DEVELOPMENT REVIEW BOARD
TRANSPORTATION DEVELOPMENT

DRB Project Number: 1008585
Avalon Subdivision-
Utility Trailer Sales

SUBJECT: EPC Approved Site Plan for Building Permit

DRB Project Number: 1008585 Hearing Date: 04-11-2018

UTILITY TRAILER SALES
ALBUQUERQUE NM
CONCEPTUAL
GRADING AND DRAINAGE PLAN
TIERRA WEST, LLC
5571 MIDWAY PARK PLACE NE
ALBUQUERQUE, NM 87109
(505) 858-3100
www.tierrawestllc.com

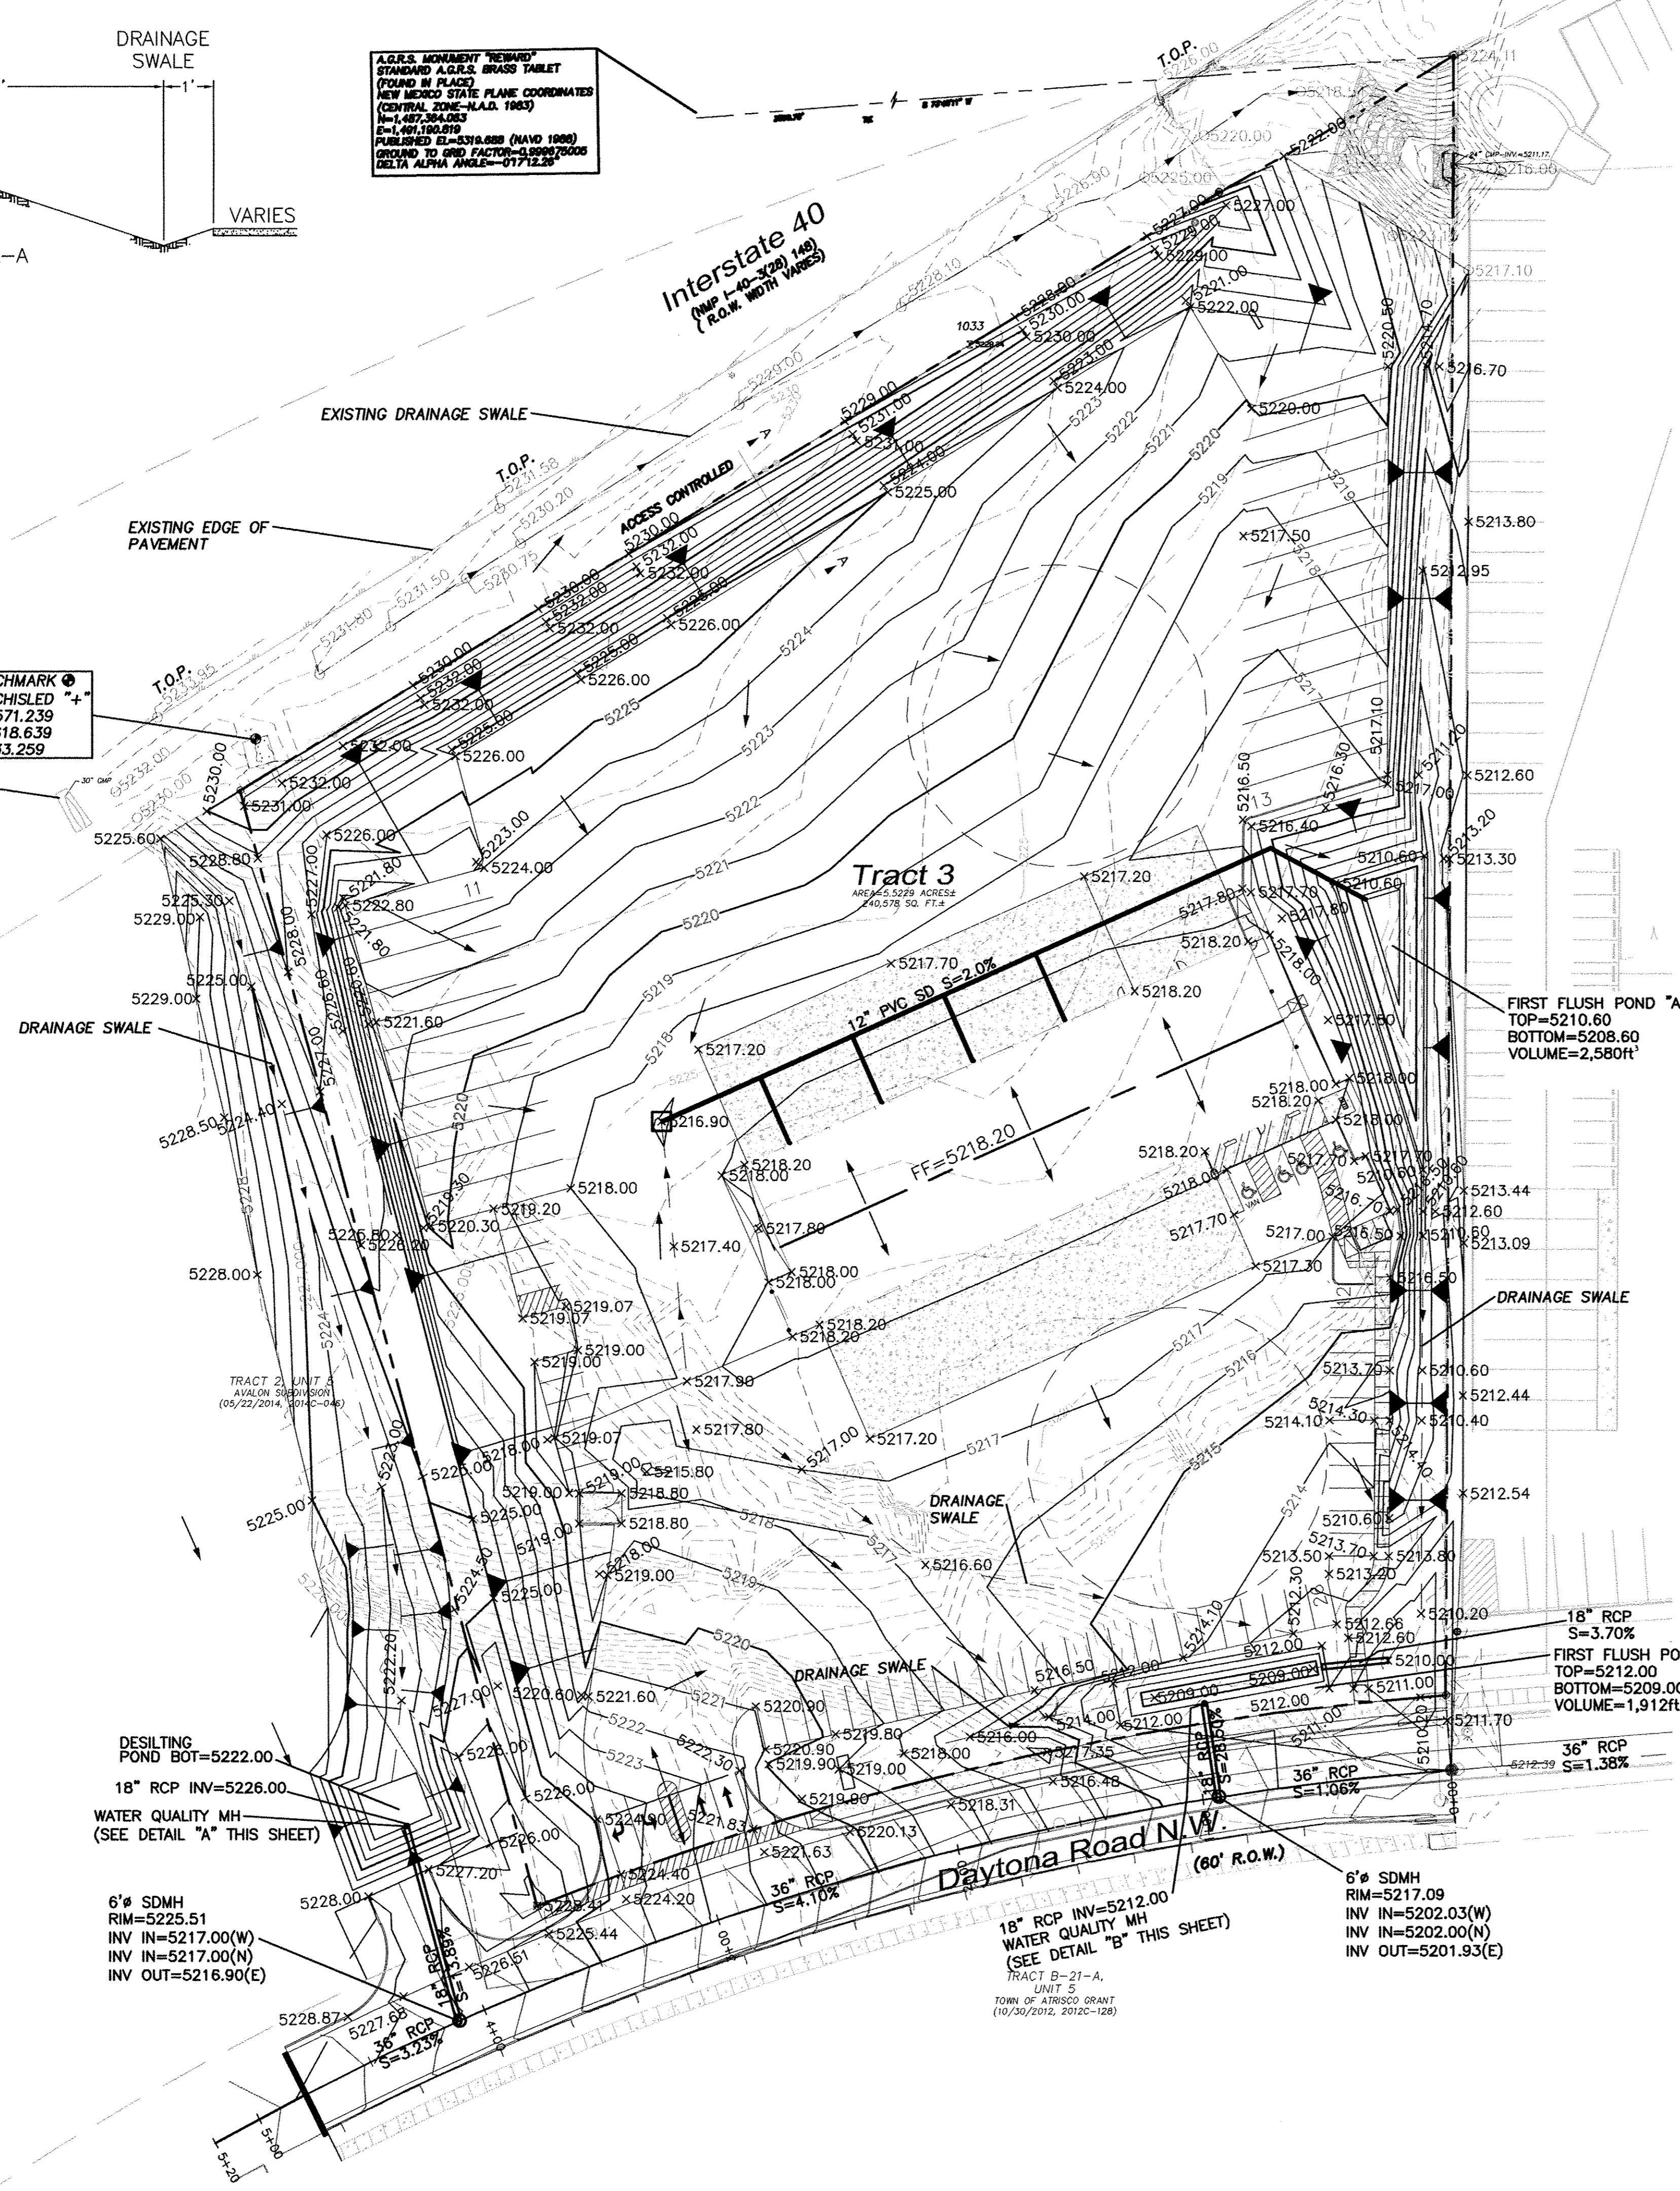
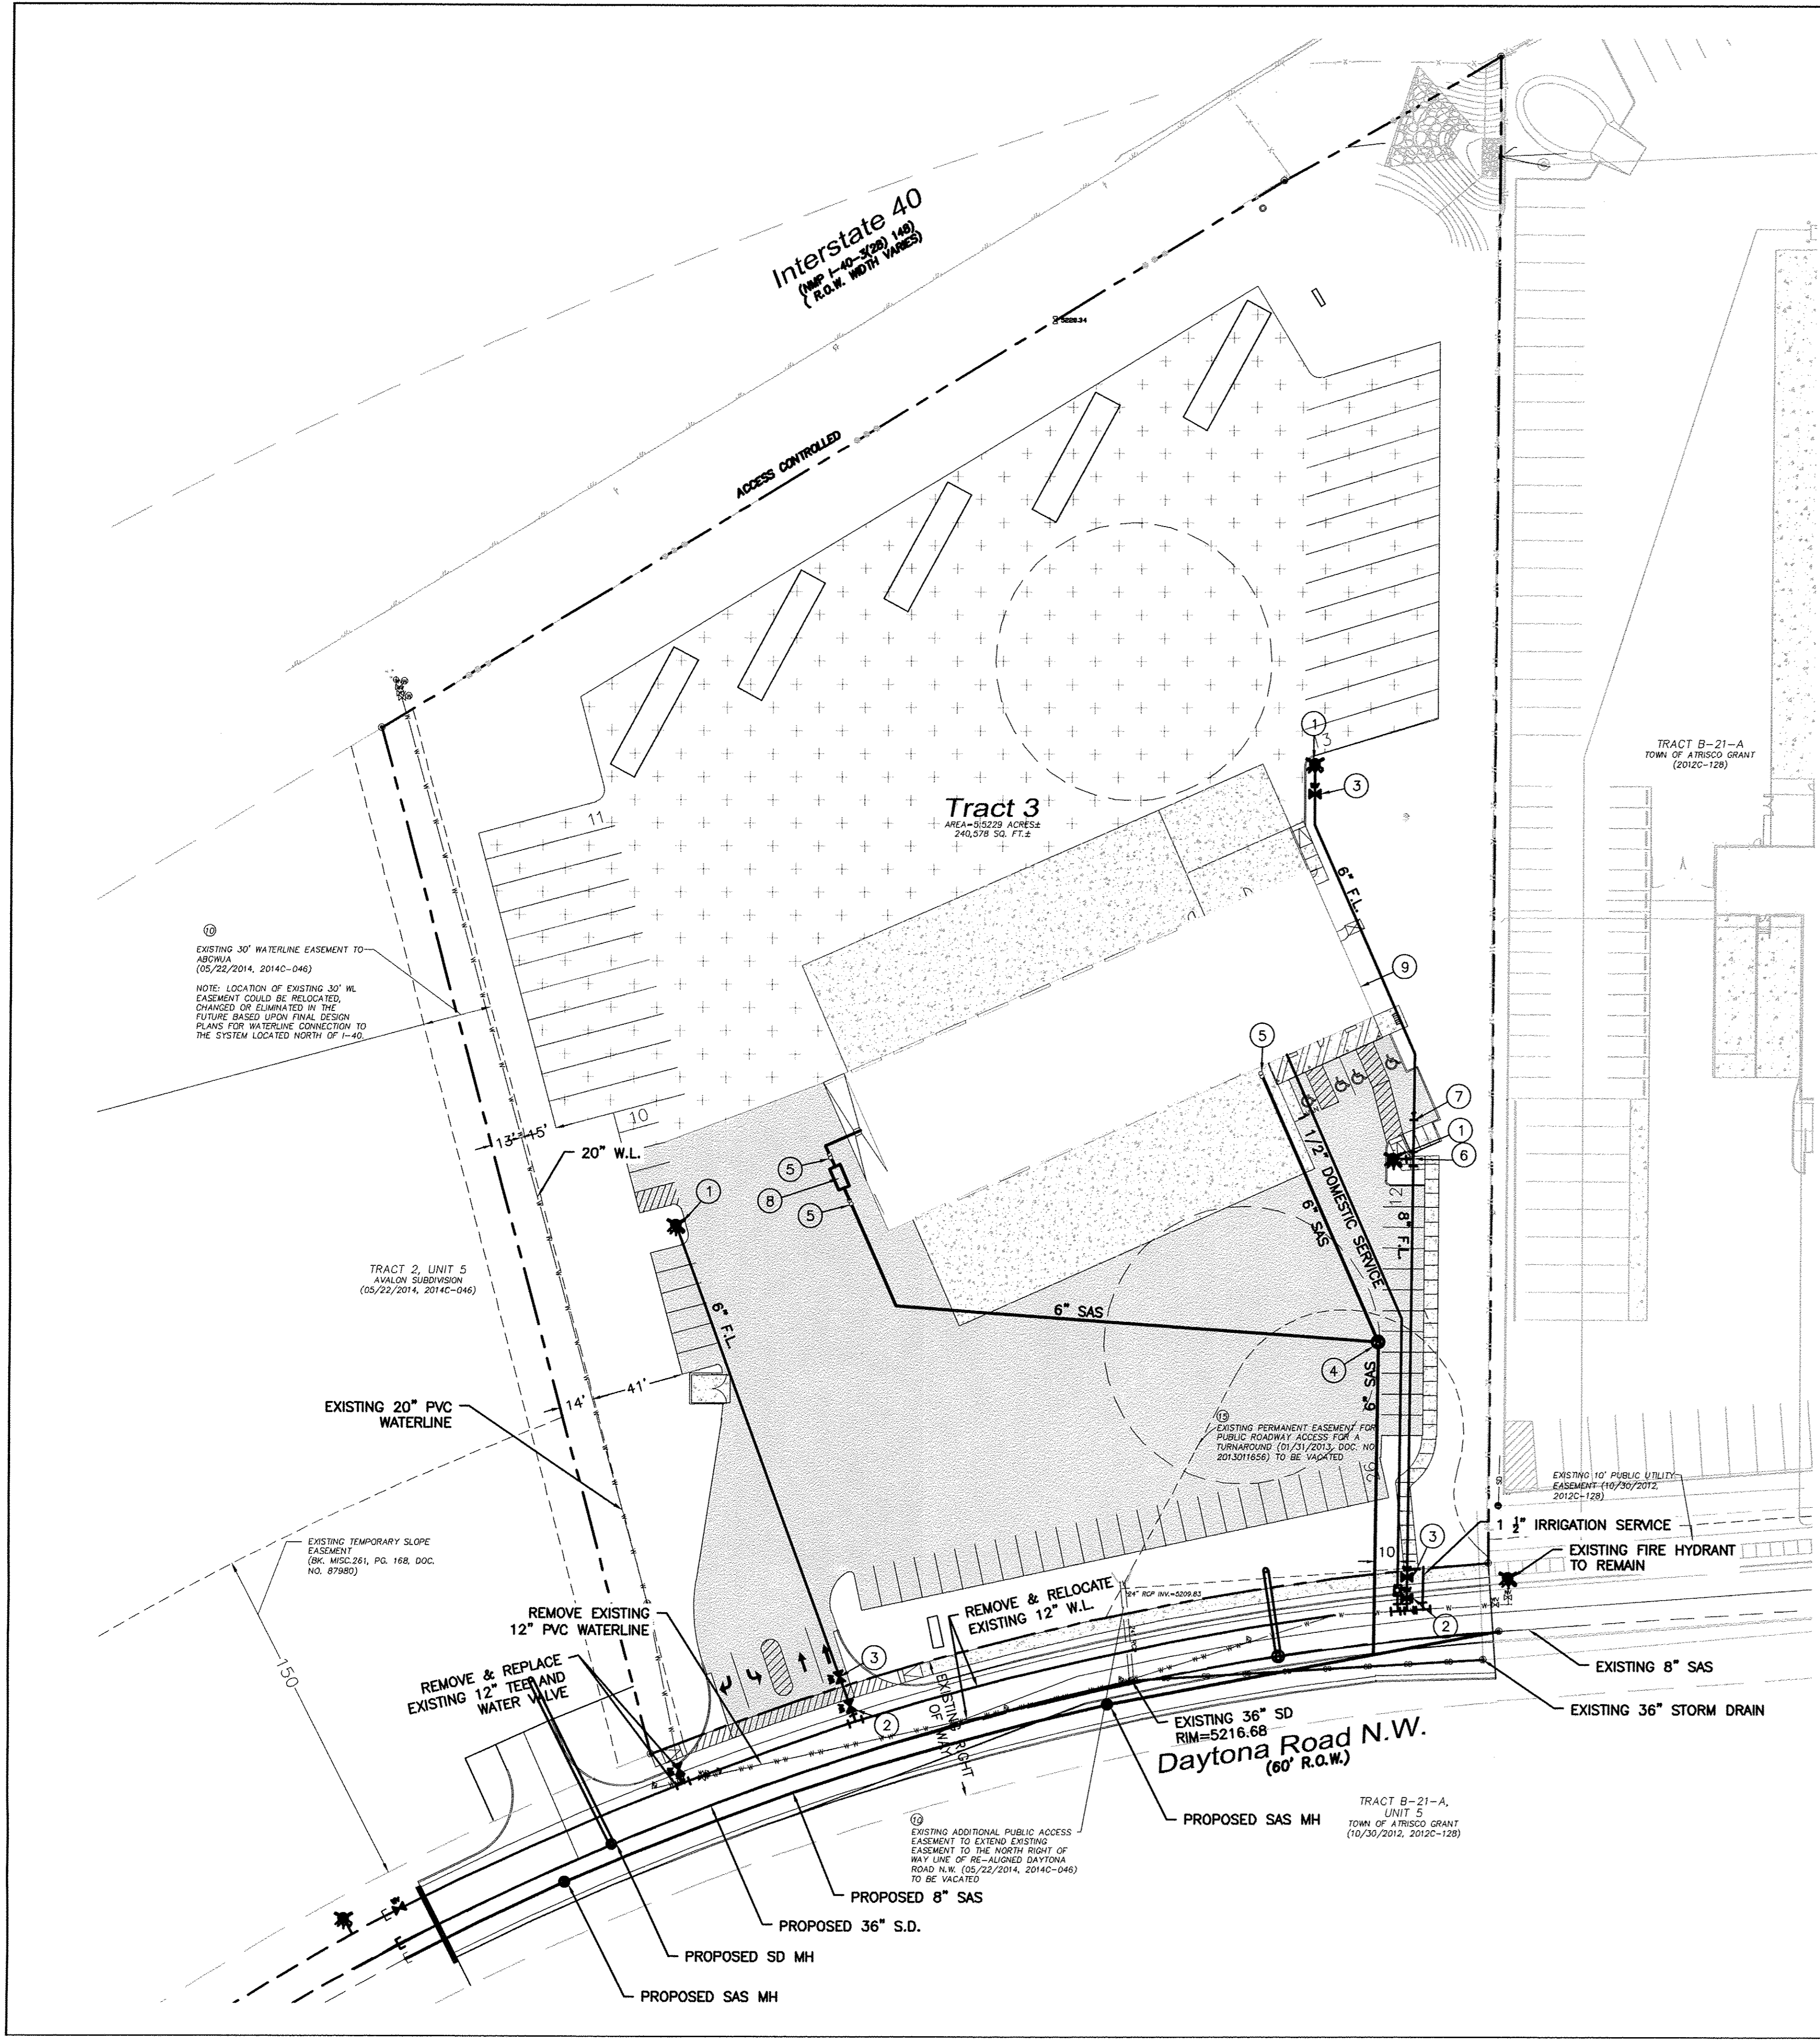
3. The grading plan does not appear to include the turnaround and is difficult to understand.
4. The curb line should not change at this property. It is shown as narrowing on both sides of the street.
5. Is the full road section to be built with additional temp curb? If so the curb should be added to the infrastructure list.
6. The fire one plan does not match the site plan.
7. Provide a public roadway easement or public right of way for the turn around.

- An approved conceptual grading and drainage plan is required
- Who maintains the riprap and gabions in the NE corner?
- Infrastructure List:
 - Add note: "Storm drain to include manholes and inlets."
 - Size and length of storm drain will need to be justified in the conceptual G&D plan

BUILDING ELEVATIONS

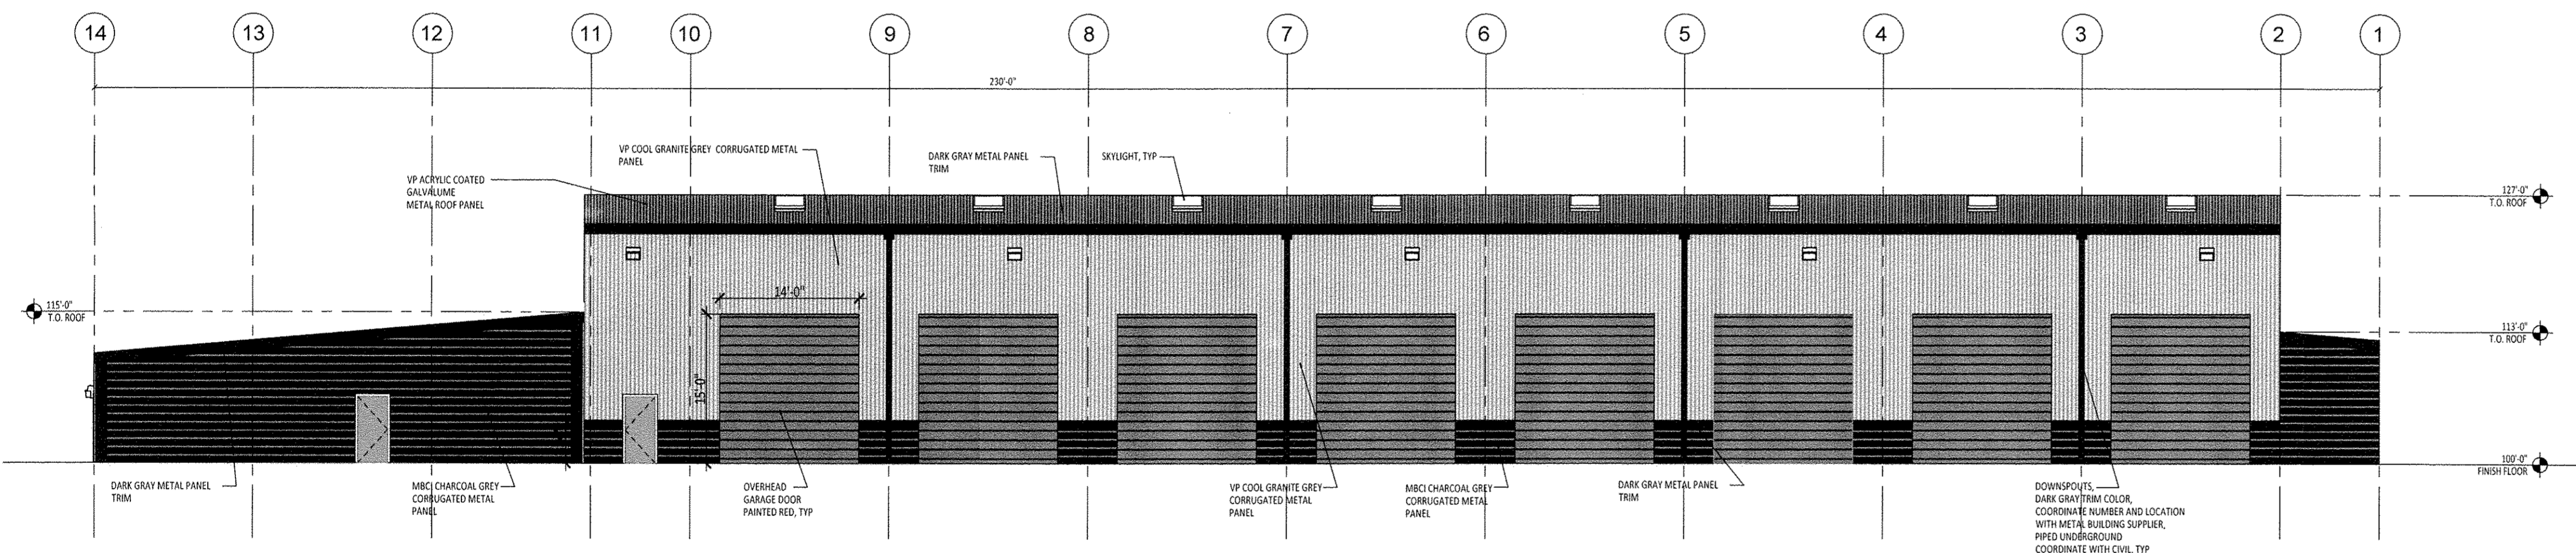
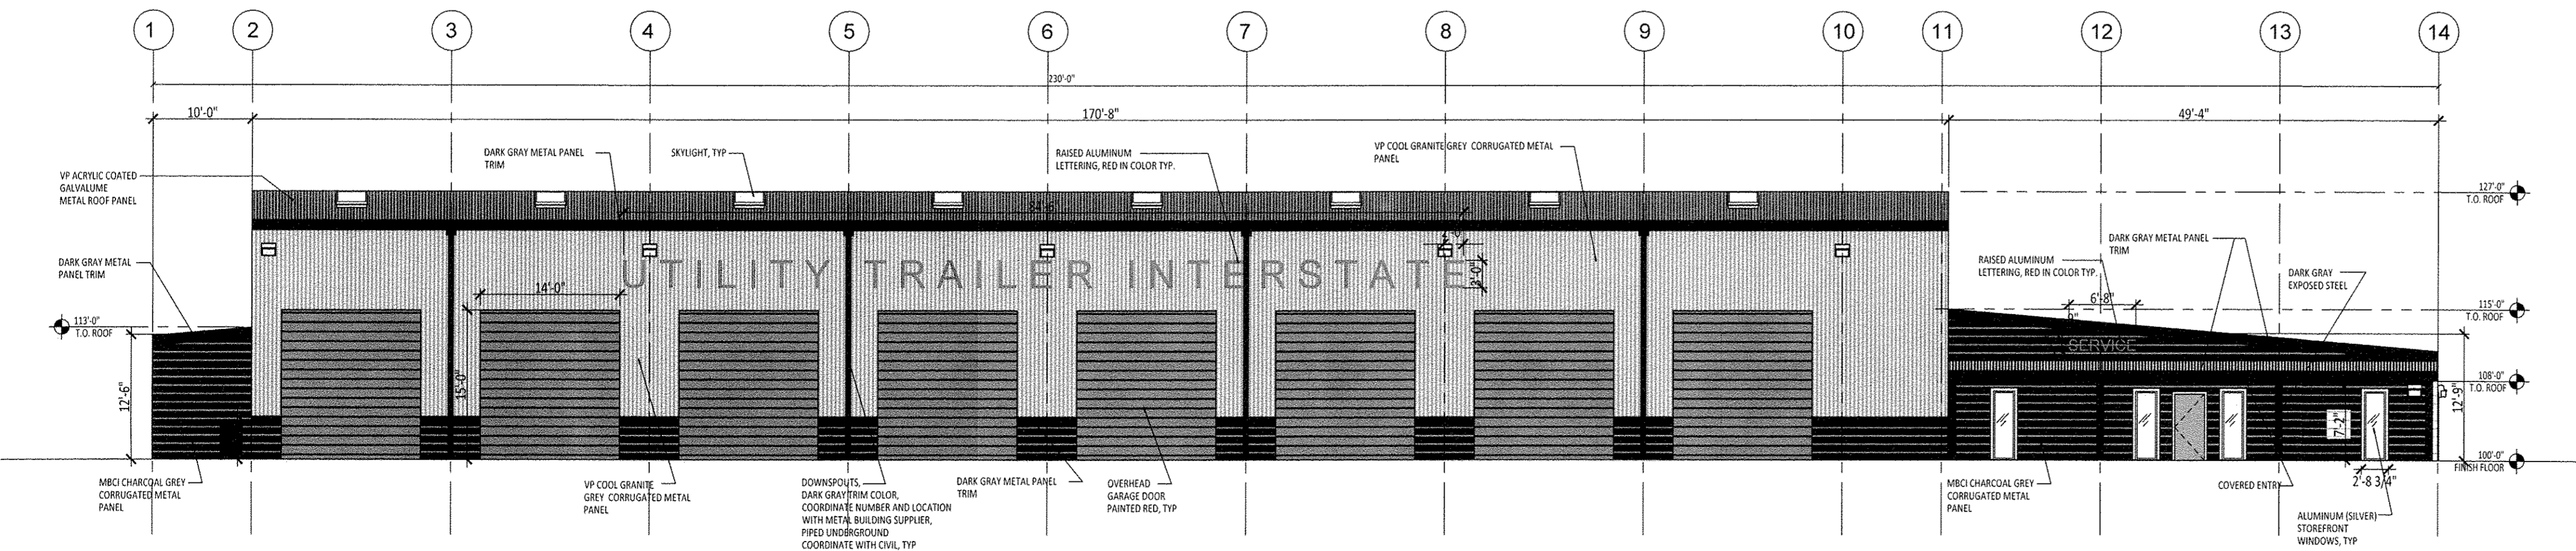
1. Condition 3 requires outdoor seating which has been added, however, there seems to be a conflict with the placement of the benches and the windows as shown on the elevations, so they should coordinate the plans with the elevations. Also, I am assuming the hatching on the sidewalk means the seating is covered, however, this should be on the legend to be clear.

2. Condition 9 requires compliance with the zoning code except as specifically approved by the EPC, and signs are subject to the underlying C-2 zone, Section 14-16-2-17 (10) (c)). Since Daytona is a collector, the free-standing sign area shall not exceed 100 square feet, and 118 square feet is being shown. Also, because there is a free-standing sign on Daytona, the building mounted sign will be limited to 12.5% of the dimension of the elevation, so the applicant should show the dimensions of the façade and the building mounted sign.
